Forge Farm, Bestwood Road, Nottingham

Highway Impact Statement

May 2021

- 1.3 This Highway Impact Statement has been prepared to support a future Planning Application to Gedling Borough Council. Pre-Application highways comments have been received from Nottinghamshire County Council (NCC) acting in their role as the local highway authority, on 16 December 2020. A summary of the comments made by NCC is as follows (**Appendix B** contains a copy of the full comments):

PROPOSED GROUND FLOOR PLAN 1:200

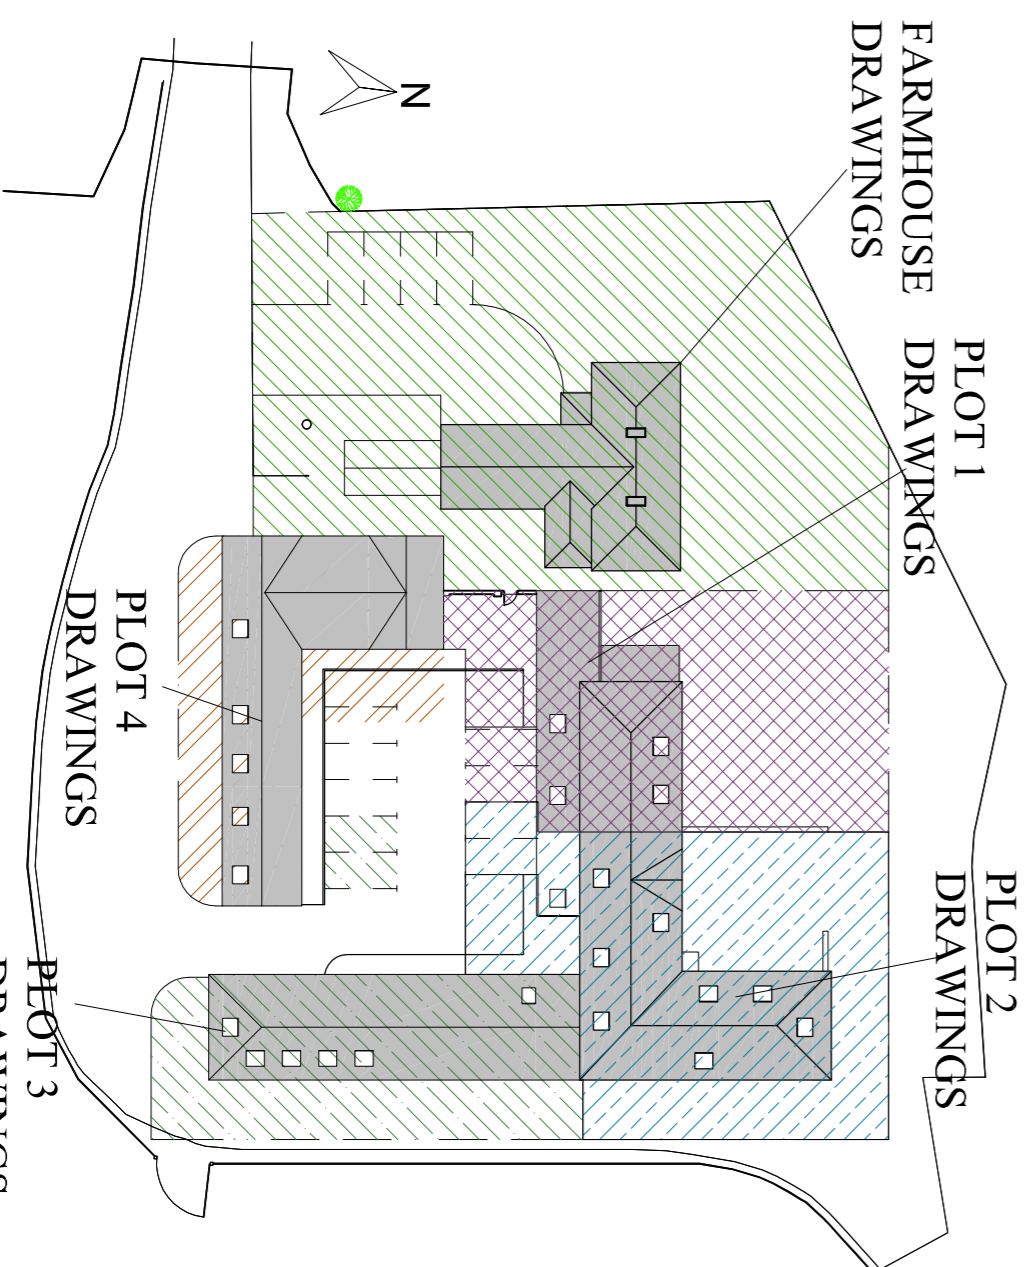
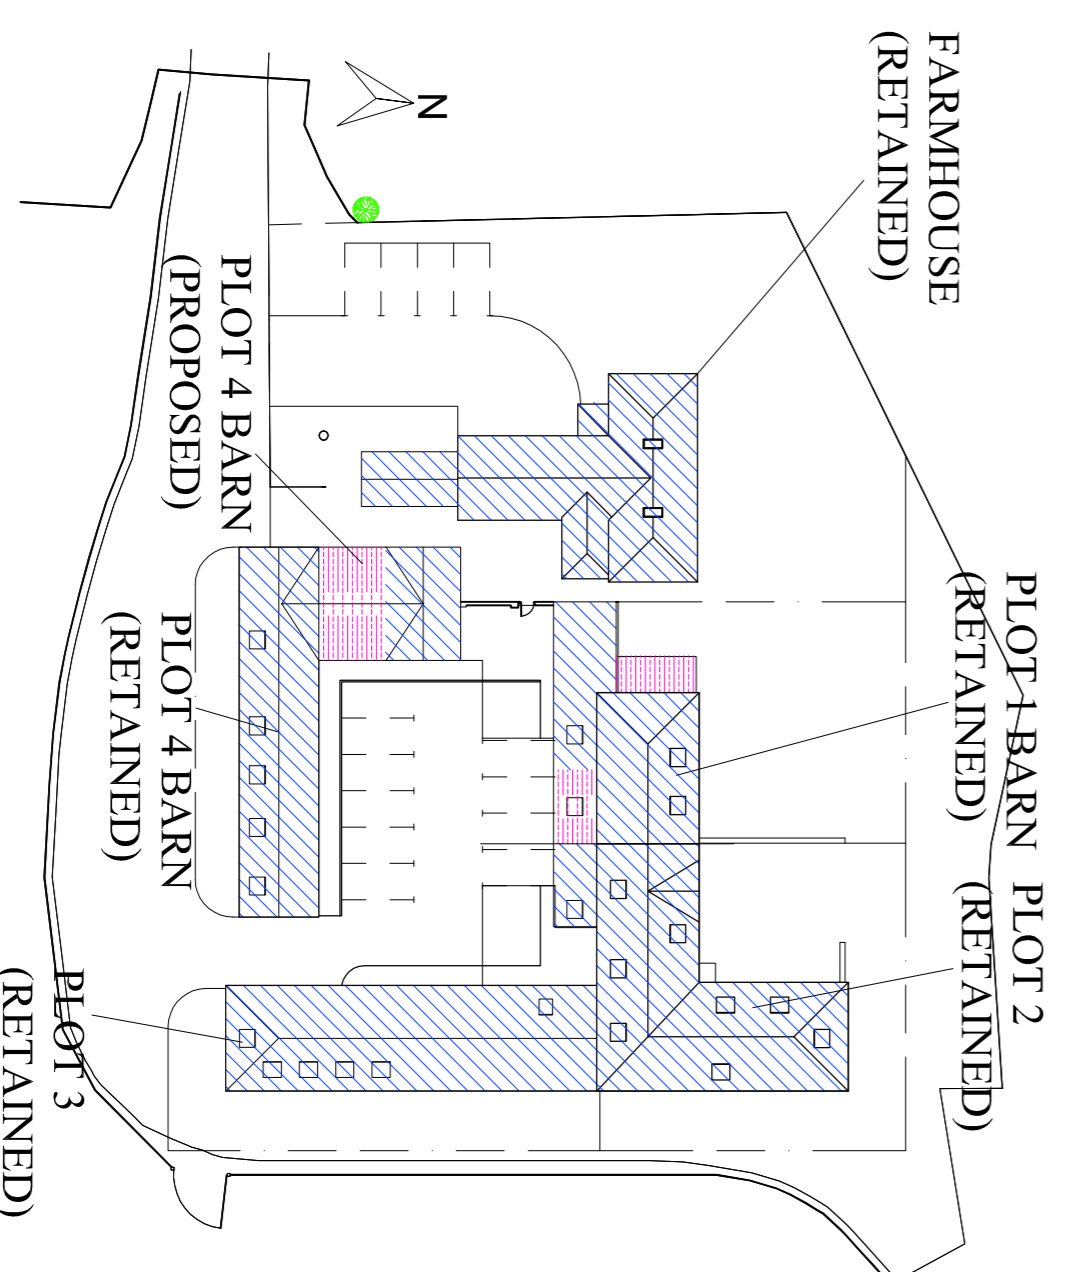
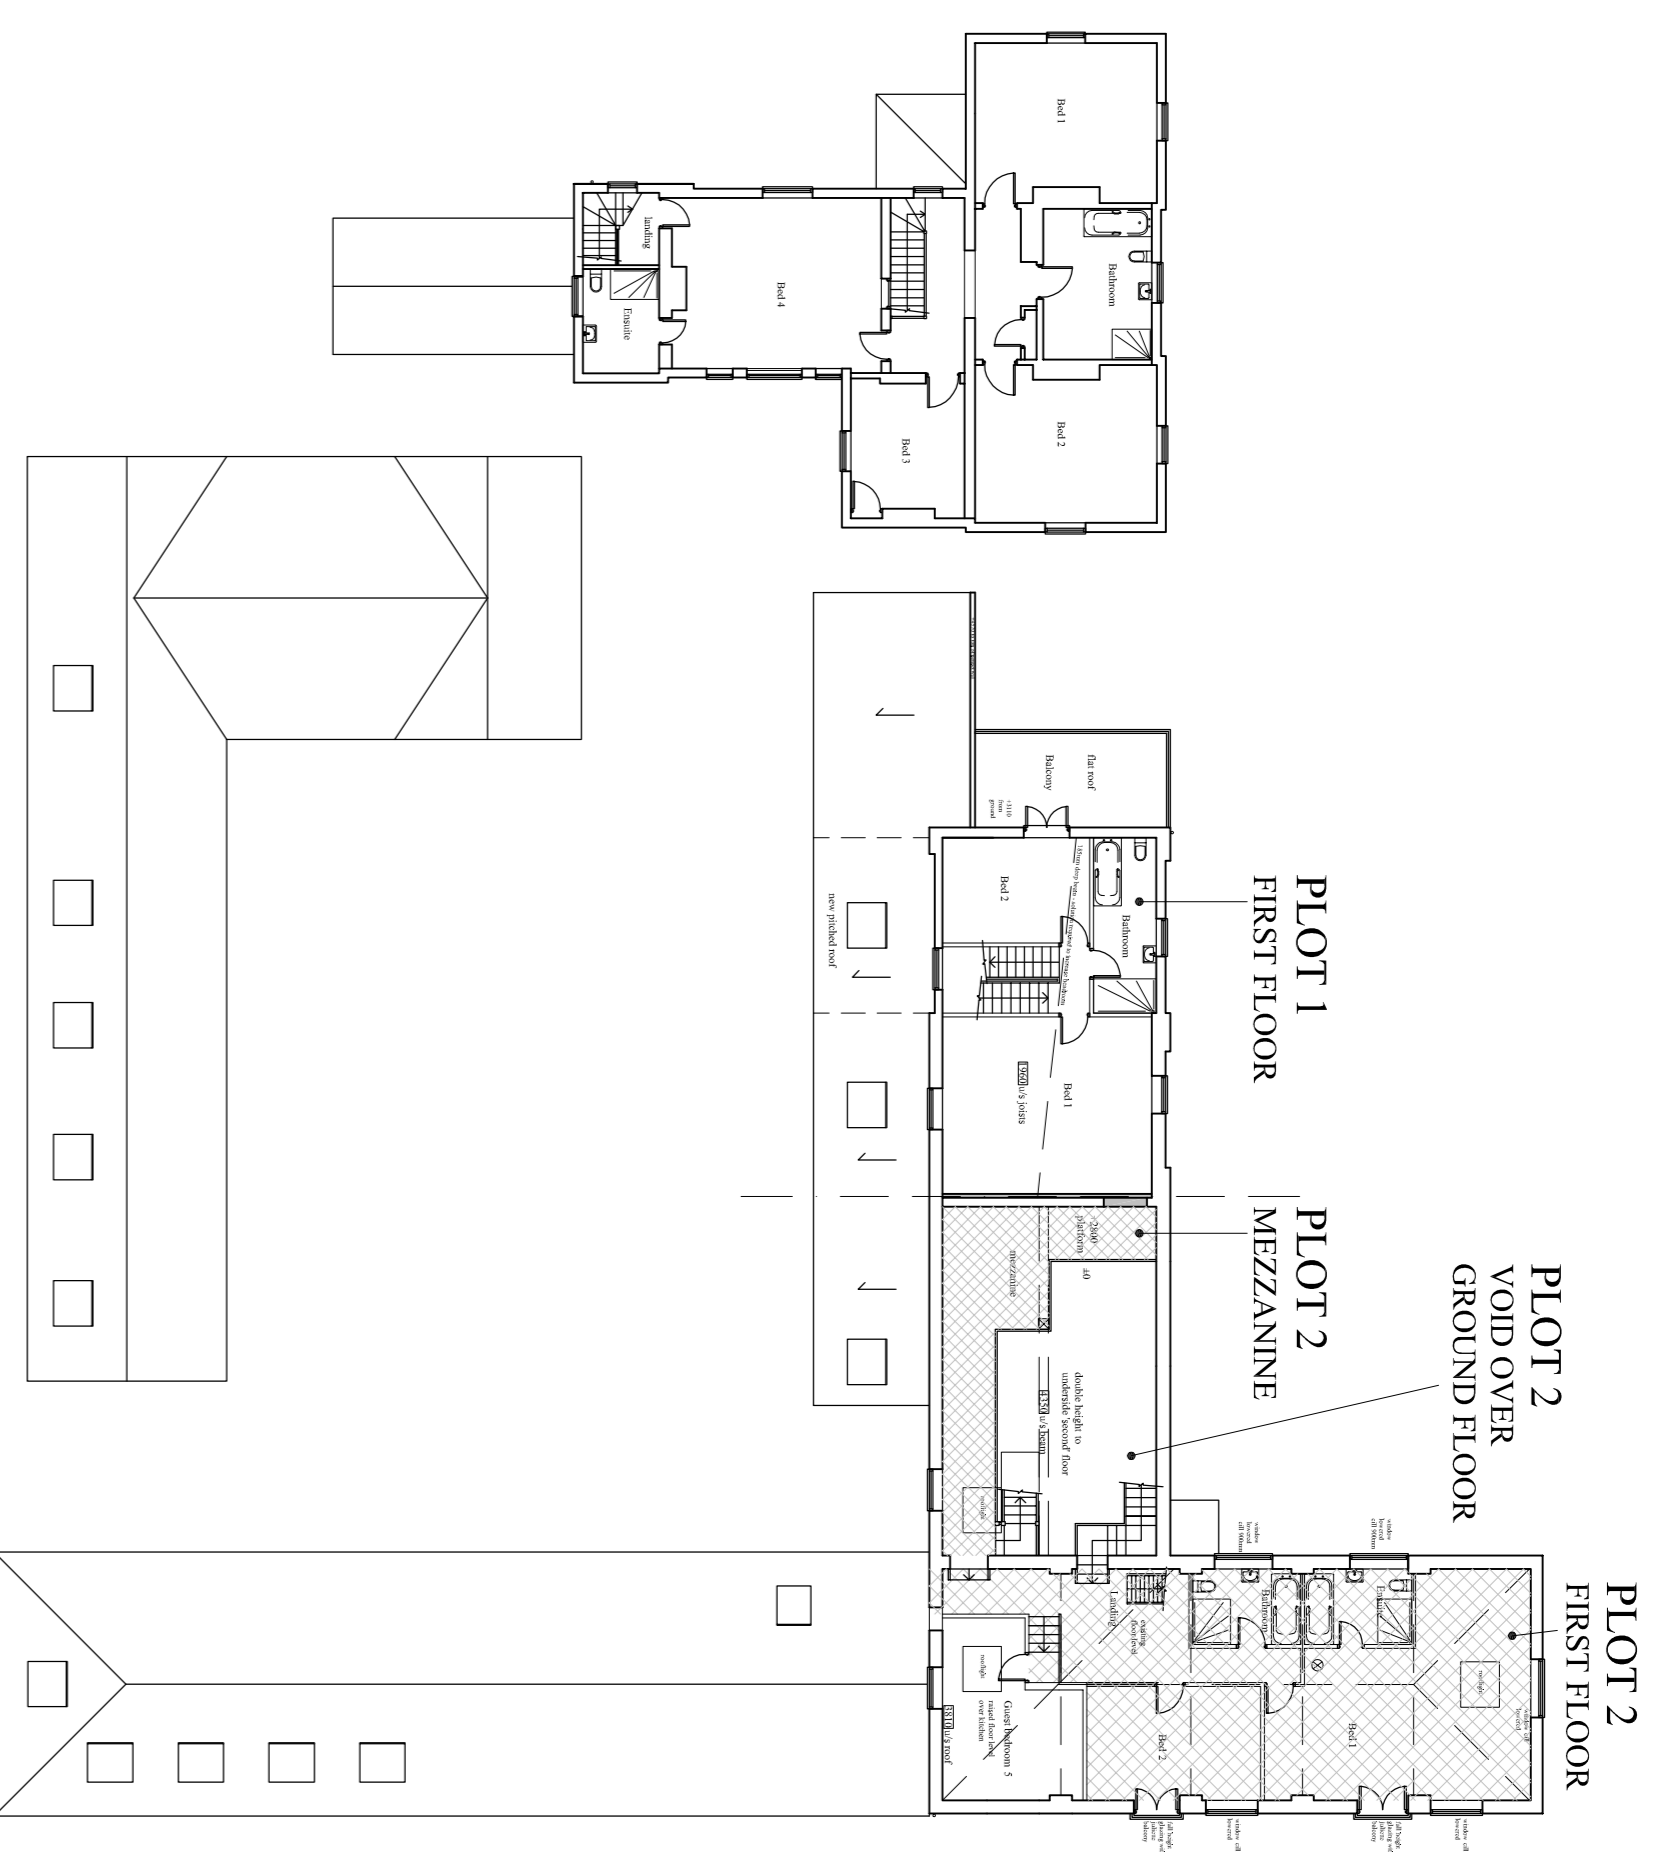
“Parking Layout will need to be 2.4m x 4.8m with a 6.0m aisle width to reverse from the spaces. Full dimensions will need to be shown on a plan. The proposed use will intensify the use of a sub-standard access.”

- 3.1 In NCC's comments it was stated that the "*parking layout will need to be 2.4m x 4.8m with a 6.0m aisle width to reverse from these spaces. Full dimensions will need to be shown on a plan.*" **Appendix E** contains a plan that demonstrates how 12 parking spaces would be provided at the site within an area previously occupied by the cattle shed. The plan also contains the dimensions of these parking which confirm that each space would be 2.4 metres wide and 4.8 metres long in line with the requirements. The parking layout also includes a 6 metres wide aisle width to accommodate vehicles entering and exiting the parking spaces. NCC should therefore be satisfied that a suitable parking layout has been provided for the proposals.

- 4.4 **Appendix E** contains a plan that demonstrates how 12 parking spaces would be provided at the site. The plan also contains dimensions of these parking spaces which confirm that each space would be 2.4 metres wide and 4.8 metres long in line with NCC’s required dimensions. The spaces would also include a 6 metres aisle width to accommodate vehicles entering and exiting the parking spaces. NCC should therefore be satisfied that a suitable parking layout has been provided for the proposals.
